Our ref: 21/0025/PREAPP
Your ref:

Erect 3 x dwellings with parking at Land East Of 12 High Causeway Whittlesey Cambridgeshire

GROUND FLOOR - Proposed 1:50

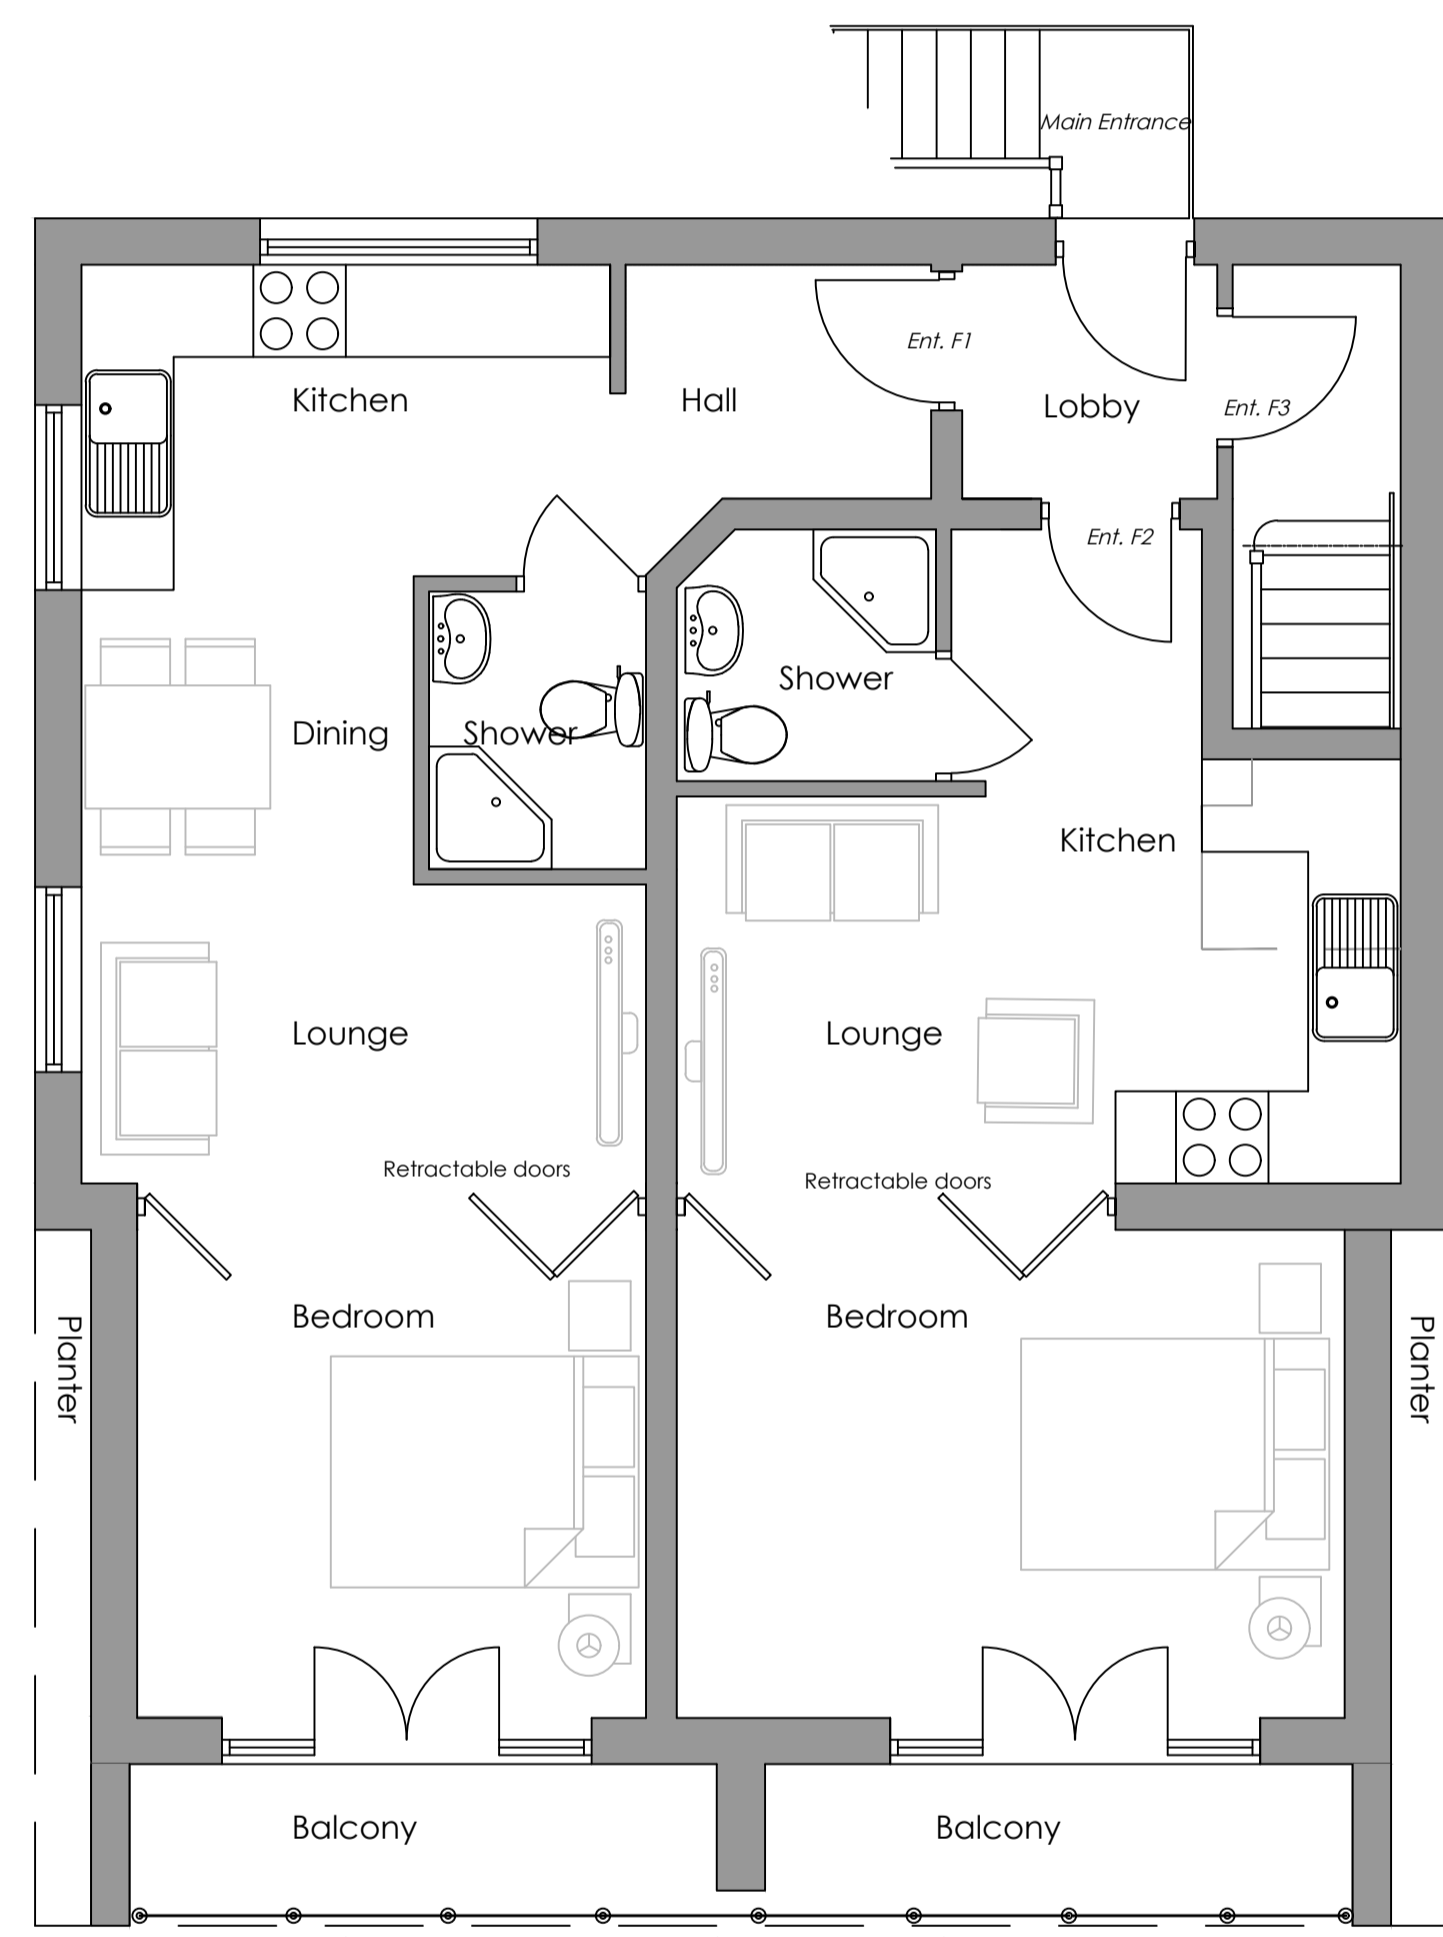
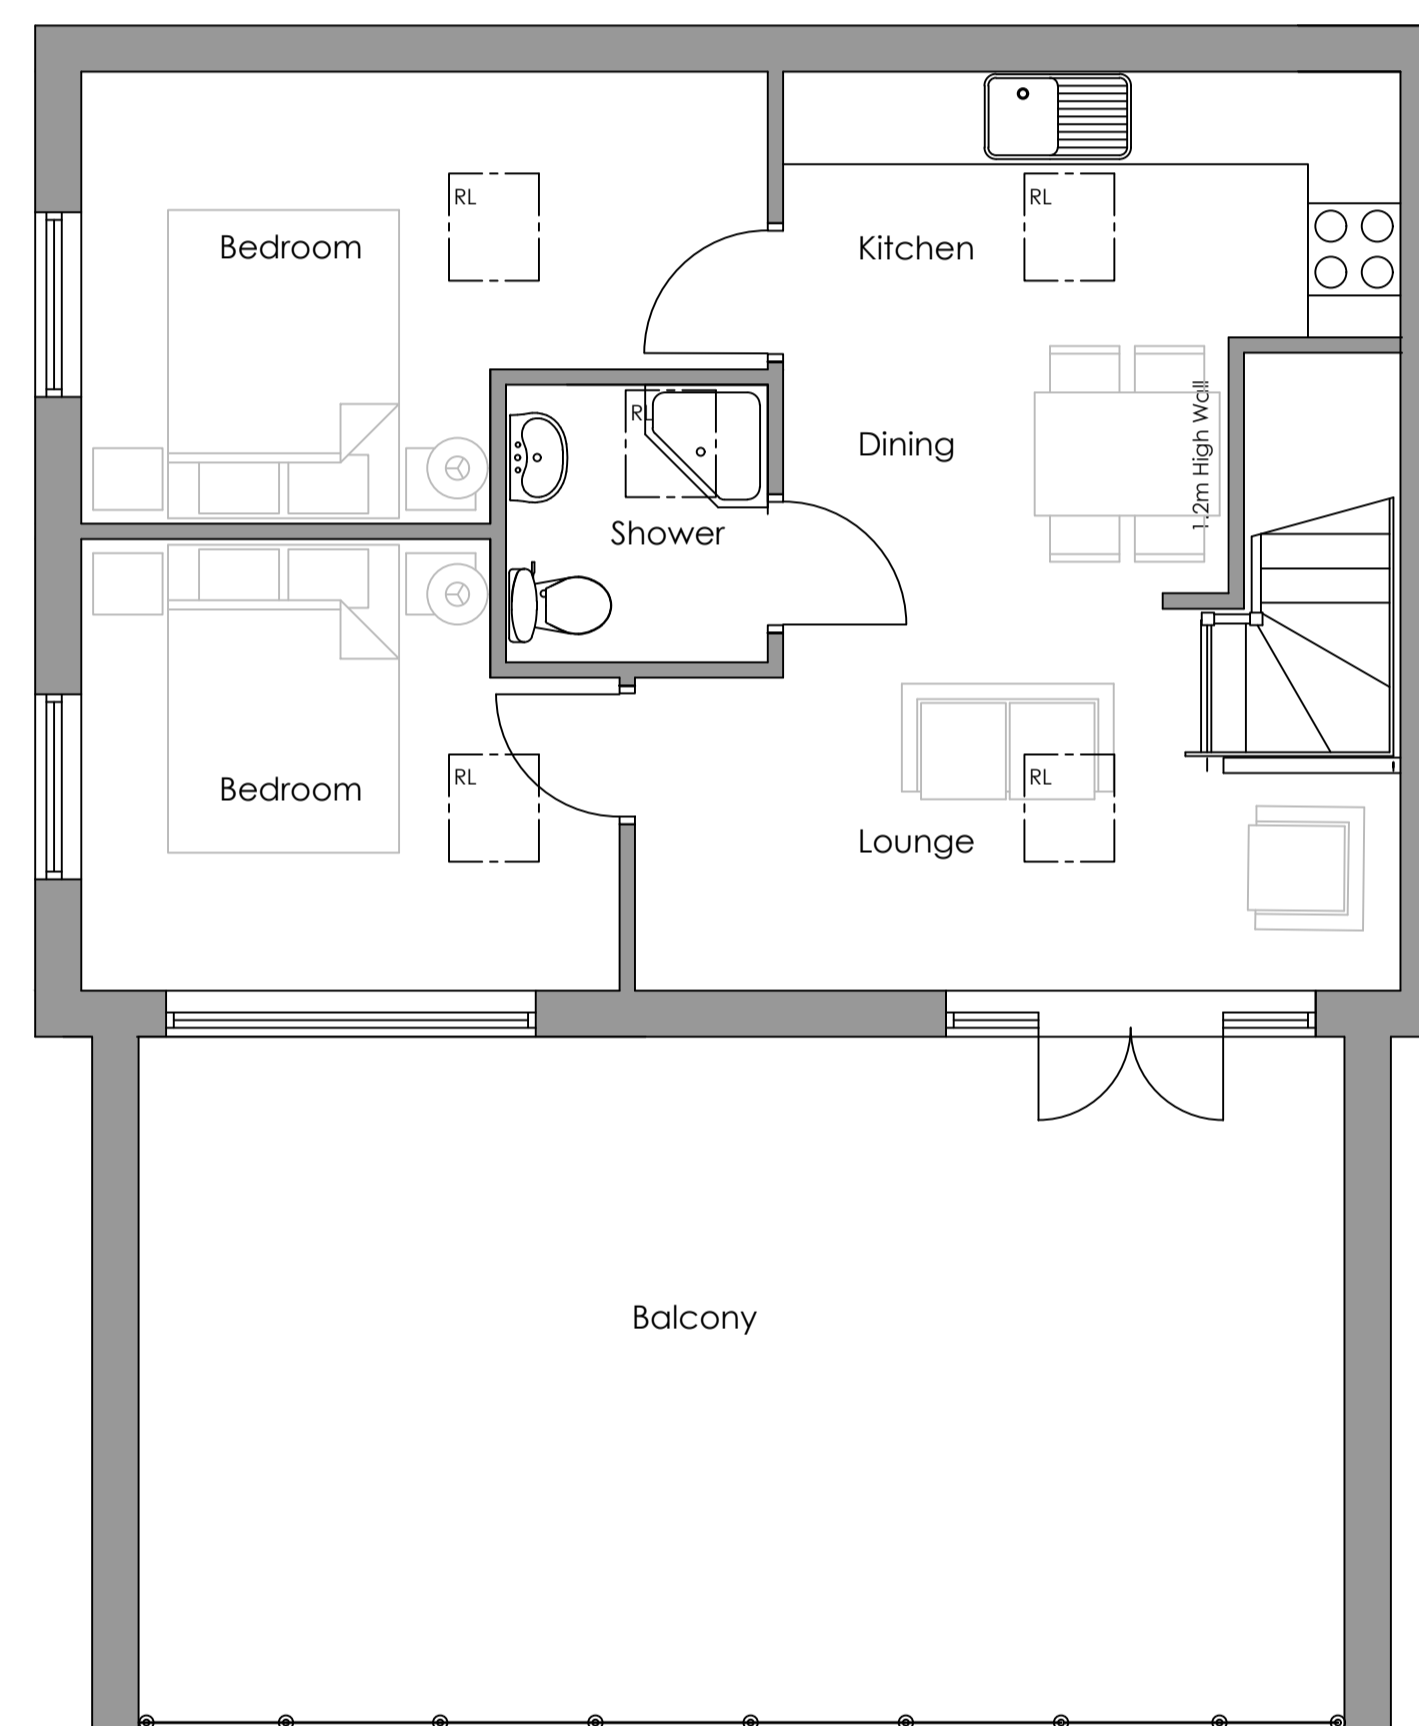
Looking finally at servicing and parking arrangements it is noted that the enquiry is silent with regard to refuse collection and for a development of this nature it is anticipated that shared provision would be in place. Such provision should accommodate 920 litres of external refuse storage capacity in accordance with the Cambridgeshire RECAP Waste Management Design Guide. Given the 'in principle' issues with the scheme I have not sought further advice regarding this matter from our Refuse Team however should your client wish to move forward with an application it is suggested that this matter is further explored. Detailed guidance regarding the waste management is available at the following link [RECAP waste management design guide - Cambridgeshire County Council](#)

In respect of parking it is noted that three spaces are shown in the under croft area of the proposed building to serve the development, this represents a shortfall of one parking space when applying the parking standards outlined in Appendix A of the Fenland Local Plan; however it is accepted that this is a central town centre location and as such a reduction in parking provision is considered appropriate. That said I do have reservations with regard to whether the scheme shown represents a workable arrangement in terms of manoeuvring, especially when factoring in the supporting section of the roof over at the south-eastern corner of the building (although it is noted that the drawing is annotated to indicate the option of a cantilevered corner). Going forward I would ask that any detailed submission clearly details turning provision for each identified space.
